**From:** Kent Rowe <KRowe@sfgfunds.com>  
**Sent:** Thursday, August 02, 2018 11:20 AM  
**To:** Lindsey Ozbolt  
**Subject:** Suncadia Phase 3 Division 14, L:P-1800002  
**Attachments:** EN-02-2018-02-19.pdf

# Site Development Plan Phase 3 Division 14 Tumble Creek February 19, 2018

**Site Development Plan Phase 3 Division 14**  
Tumble Creek  
February 19, 2018

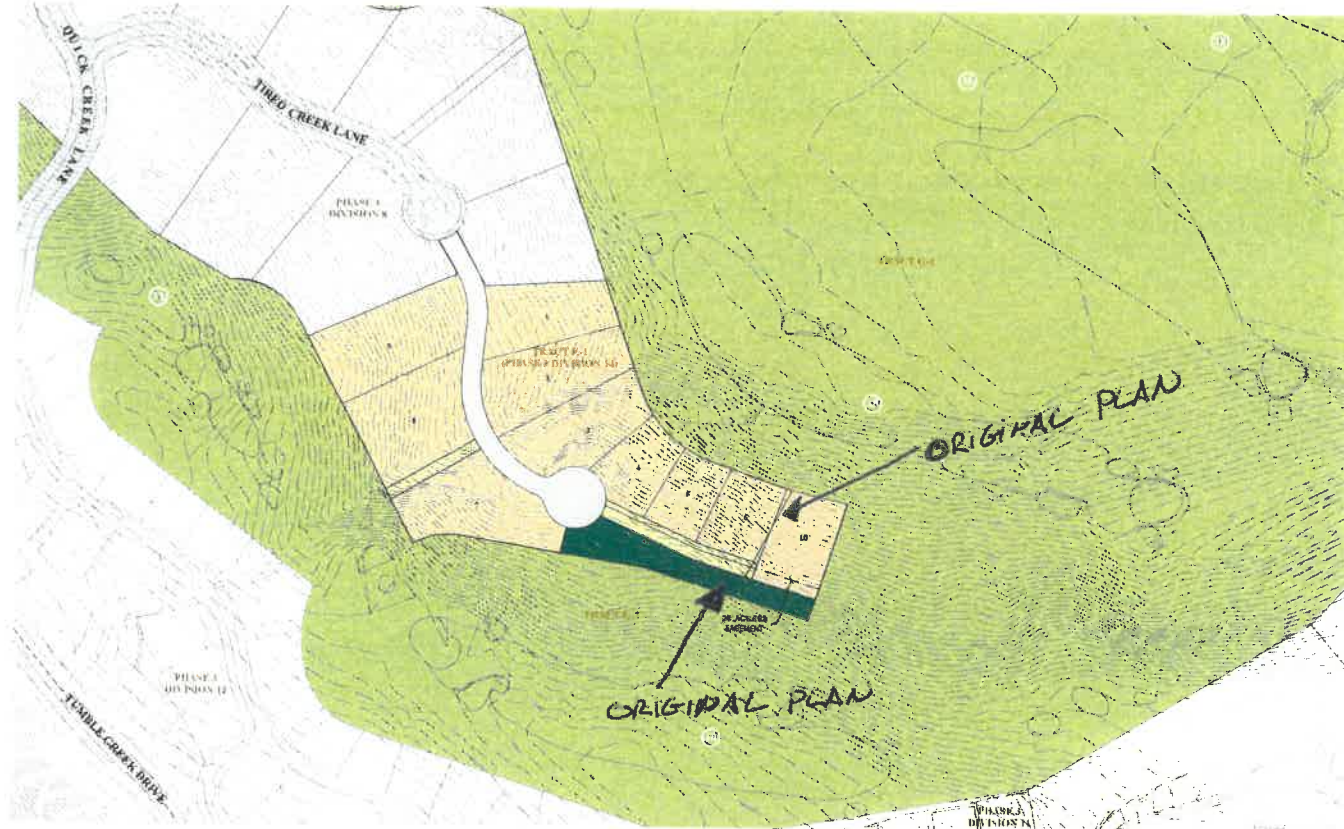
Attached you will find the Phase 3 Division 14 map which I am sure you have become familiar with by now. You will notice there is an original line breaking out the original future plan for this phase 3 Division 14. As you will also notice there are only 9 lots, NOT the proposed 10 lots the developer is attempting to ram in to this phase with no regard for the current cabin owners views or for the past promises made. I'm not saying the development should not be done, what I am saying is that the 10<sup>th</sup> lot should not be there at all. The 10<sup>th</sup> lot moves this plat into the views of the cabins and deviates from what every one on this ridge was told when they purchase their properties.

This 9 lot Phase 3 was to be developed as the 3rd and last phase of the cabins neighborhood. The original cabins were to be smaller homes bundled closer together. The heights of the original cabins did not exceed 30 ft. and this neighborhood was to be the more of the same. Restricting the height of the 9 lots would minimize the impact on all of the current cabin owners.

Again, I am not saying NO to the project, I would like Phase 3, Division 4 to be put back to the original plan of 9 lots and be held to the original height restrictions be enforced at the original 30 foot height limits as the original plan was laid out.
